From: chris barrow [REDACTED]
Sent: 04 May 2020 15:27
To: Juan Baeza <Juan.Baeza@arun.gov.uk>; Neil Crowther <Neil.Crowther@arun.gov.uk>; [REDACTED]
Subject: 49 Horsham Road - Revised Scheme.

Demolition of existing outbuilding and stair access to first floor flat and office. Erection of a Rear extension to existing retail unit, creation of new rear stairwell with access to new first floor office and new enclosed first floor amenity space.

Proposed Elevations

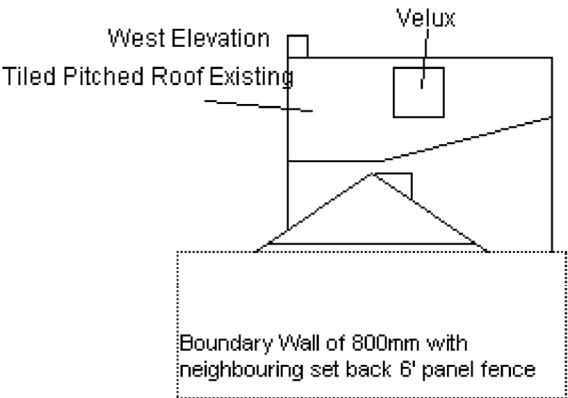
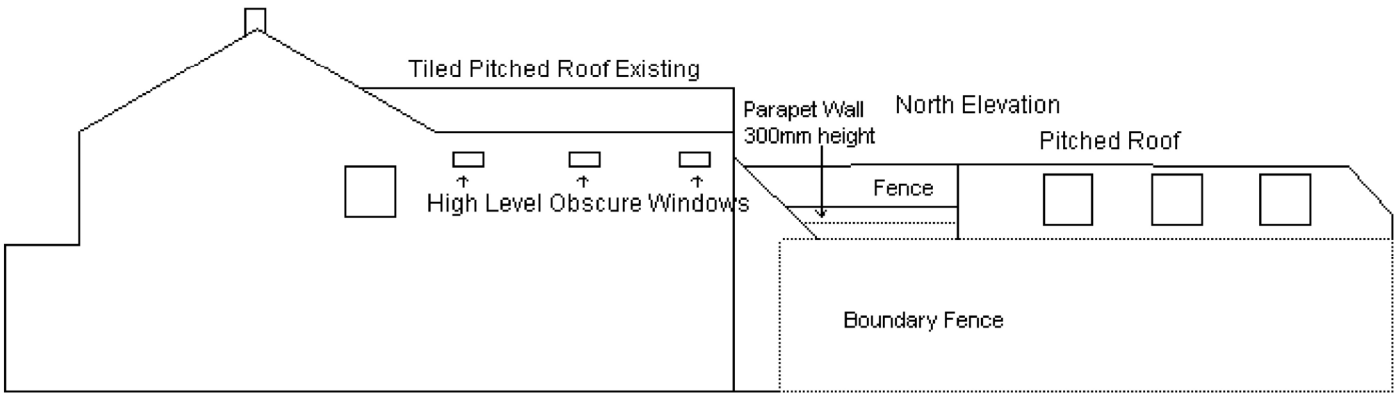
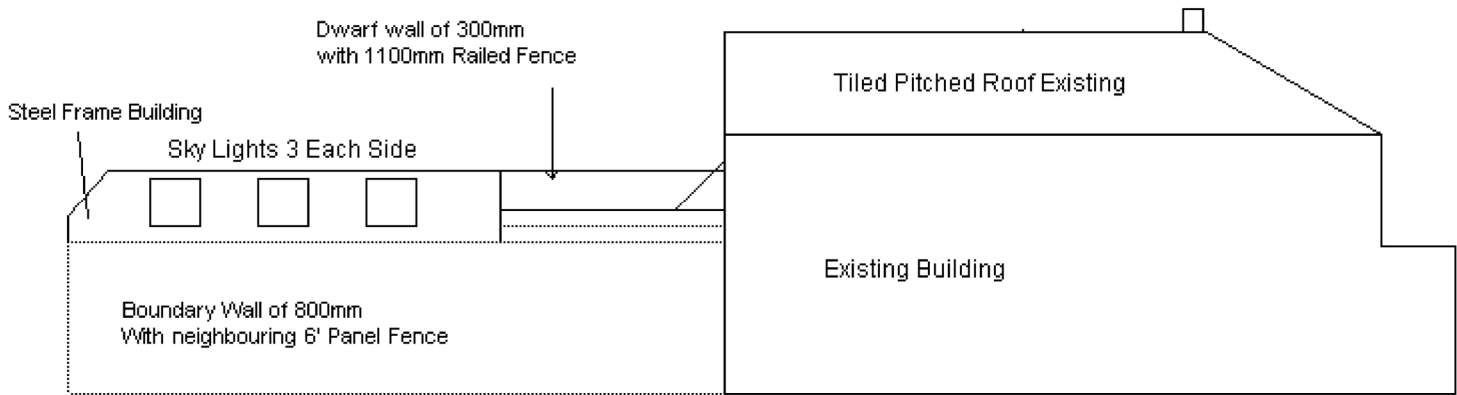
The coverage and height of the rear structure is seen to be excessive to the extent that it will have a negative impact on the character and appearance of the area and a negative unneighbourly impact on neighbouring residents. In essence what is being proposed is too much for the site and if it were to be reduced in line with what was considered under the pre application submission then a more favourable response would be given by officers. Attention would also be needed to the relocated staircase and the overlooking of views to neighbouring properties that it affords.

1. The pre app didn't show any first floor office to the existing building. Yes it did. Description shown on plan
2. The height of the pre app rear ground floor building was 4m at the pitch and 2.4m at the eaves. The proposal is now 5.25m high the pitch and 4m to the eaves. My Mistake, it shows 4.2 and should have been 5.2, as per clients instructions, but we propose to lower it to 4.5 with 3m at eaves inline with drawings. Any less would be pointless as carpets are 4 & 5 m wide, and have to stand in the centre of the building. As we have to reduce our ground 450mm to match existing shop floor, then this would bring the pitch inline with neighbouring sheds in their gardens.

We propose to lower the building to a pitch height of 4.5m, which as the ground will be reduced by 450mm level with the existing shop floor, thus allowing no further height issues. The stairway has been altered, thus not to encroach into any right of light, which is well beyond any building, If there is any issue, please do not hesitate to contact me immediately. There is a small 300mm parapet wall to the flat roof, with a fence around, so neighbours cannot access this area, and security purposes.

Proposed Floor Plans
Scale 1:100

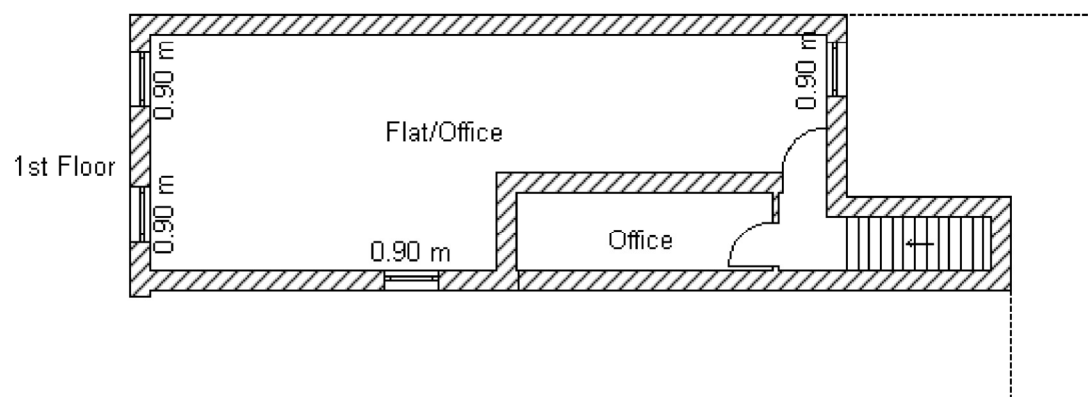
3. It is now clear given the coverage of development of the ground floor means that the only external amenity space for the first floor flat is at the top of the relocated external staircase. This is not considered to be an acceptable provision given the likely views of it from neighbouring residents. As with many flats, council and private, no outside space is allowed for, and as the flat is part of the shop premises anyway, there is no need for this space. I could list many, many properties the same, like South Terrace, St Catherines Road, Clun road, etc. There is a large park/playing fields in Southfields road which is within a few hundred meters
